Application No: Y/123/21/PL
Site Address: Land to the south of Ford Lane and East of North End Road Yapton BN18 0DS
Description of works: Variation of condition imposed under Y/82/20/RES relating to condition 1 - plans condition.

Thank you for your internet representation made on 24th November 2021 which has been recorded as no objection with the comments as follows:

OWPC42141

**Title:**  
PLANNING LAYOUT

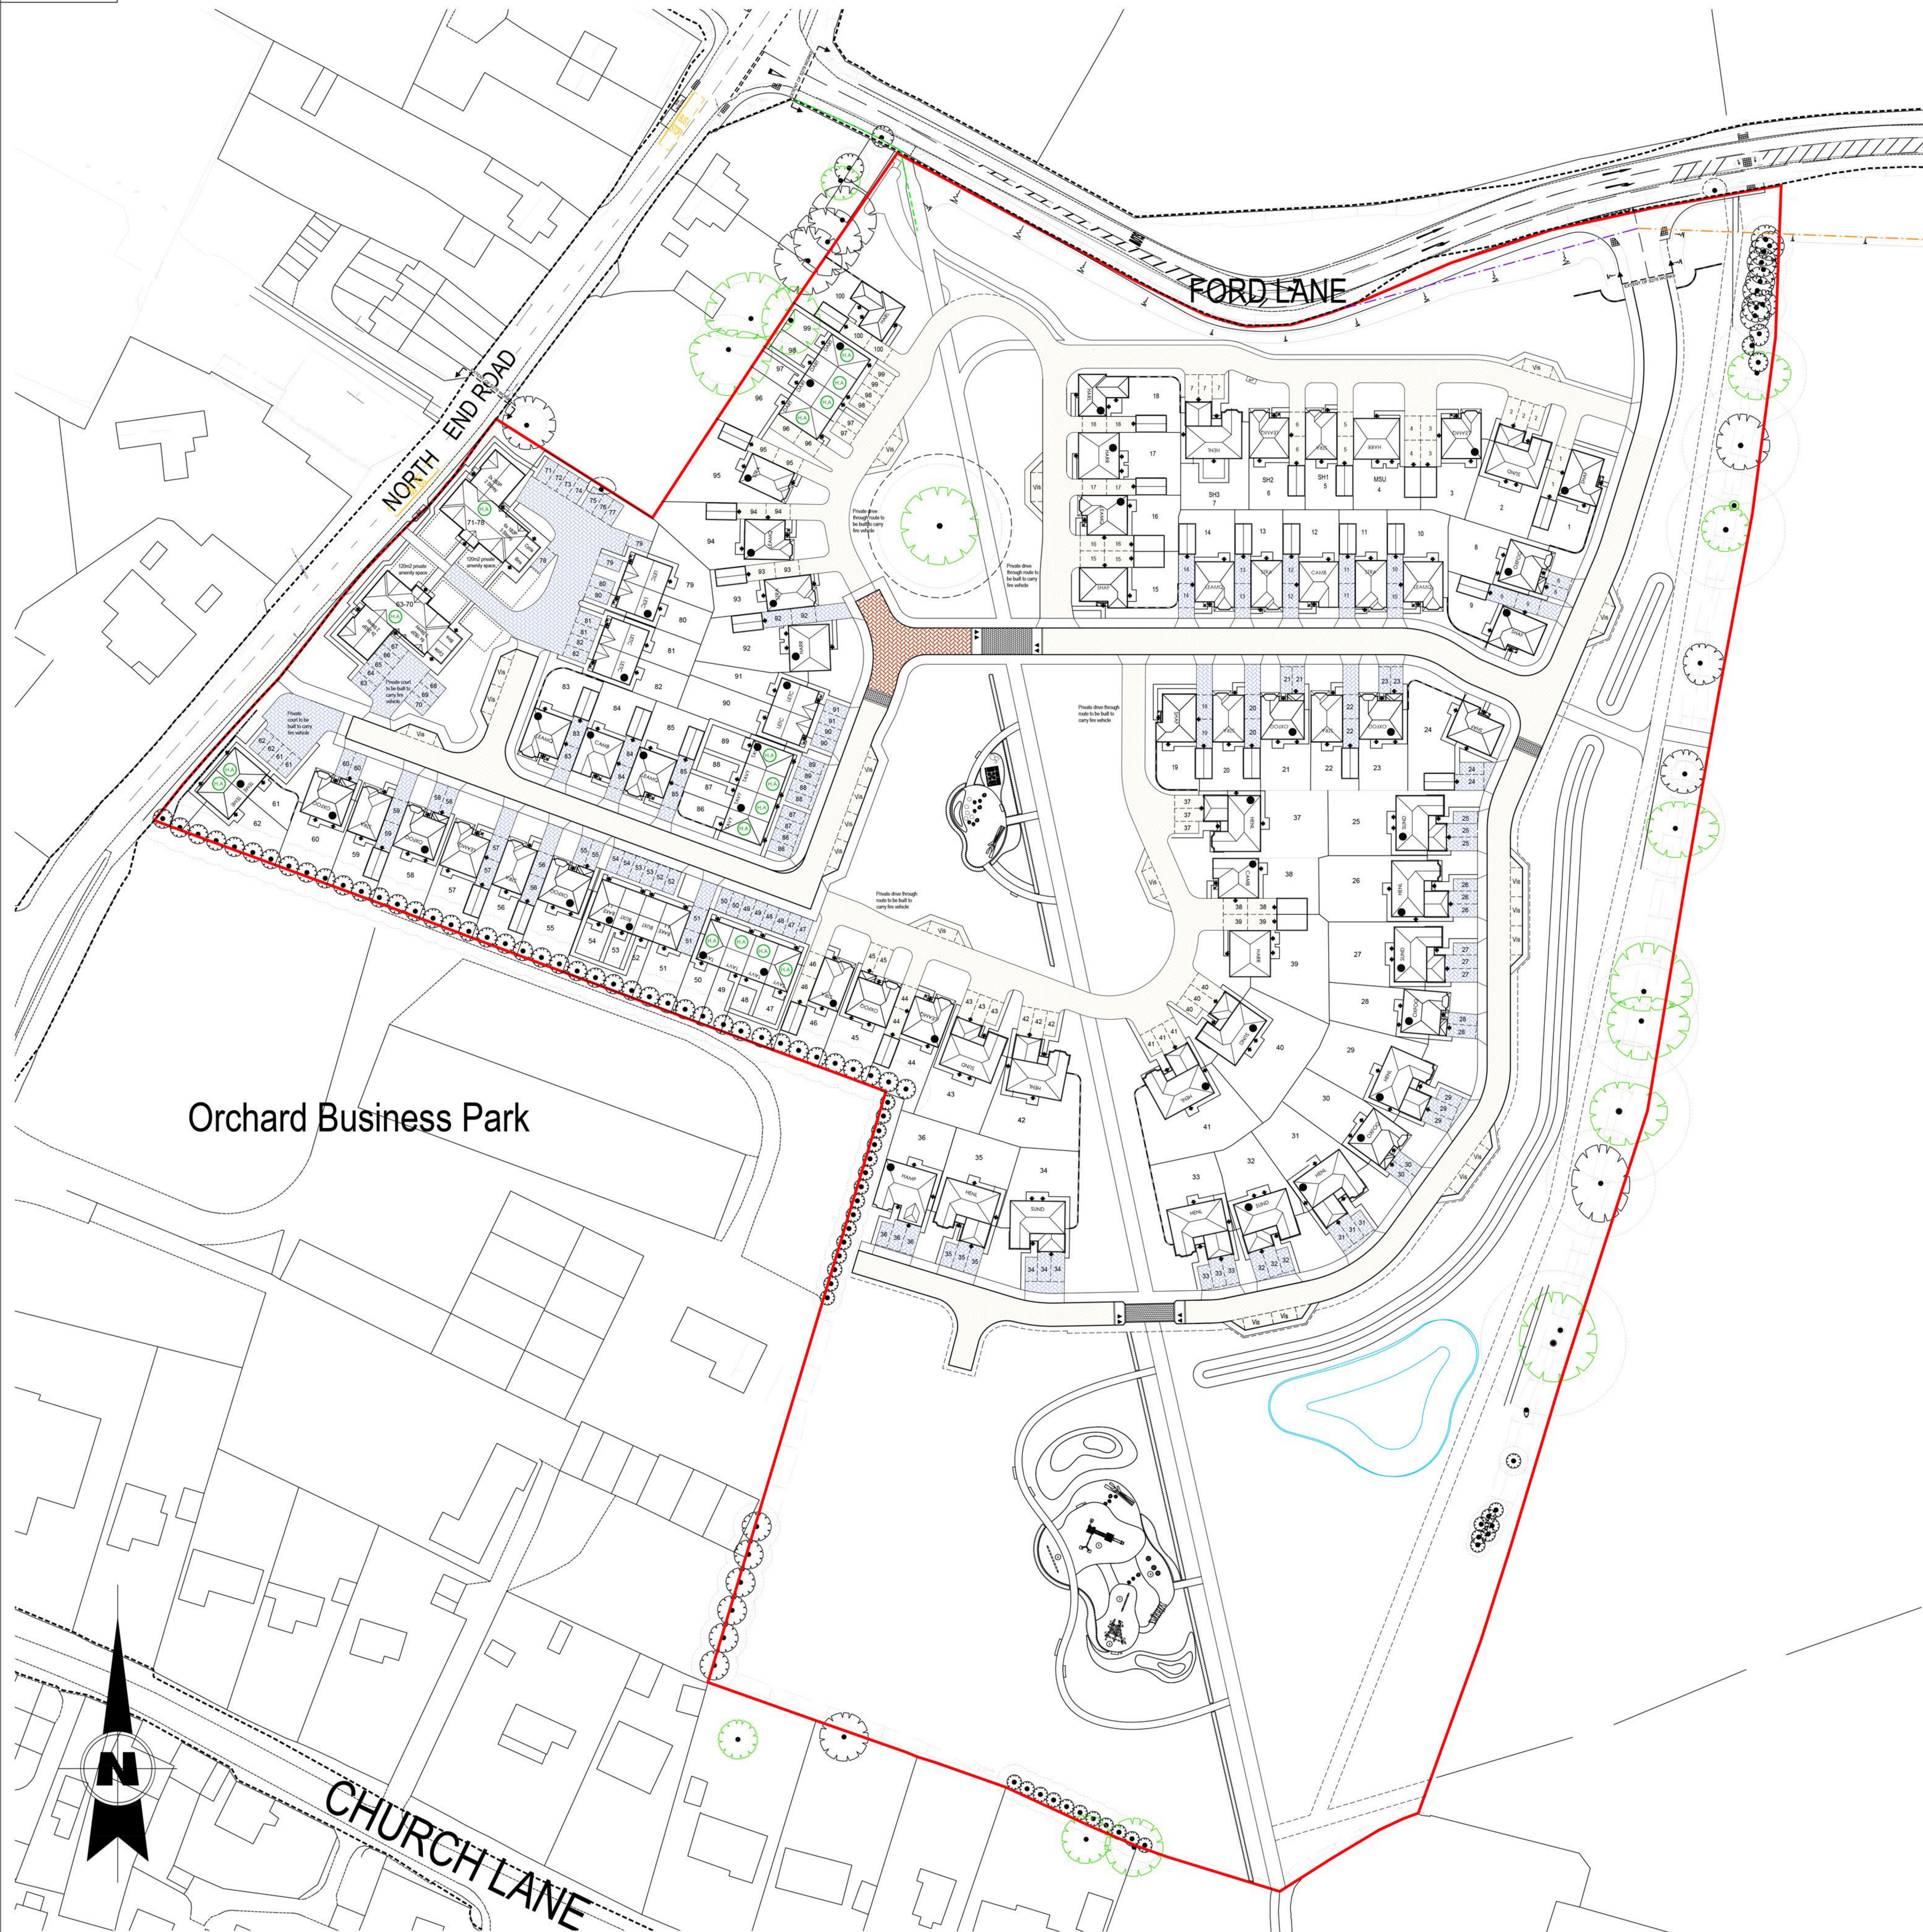
YPC are pleased to note that the applicant has relocated the southern most play area away from the water collection pond.
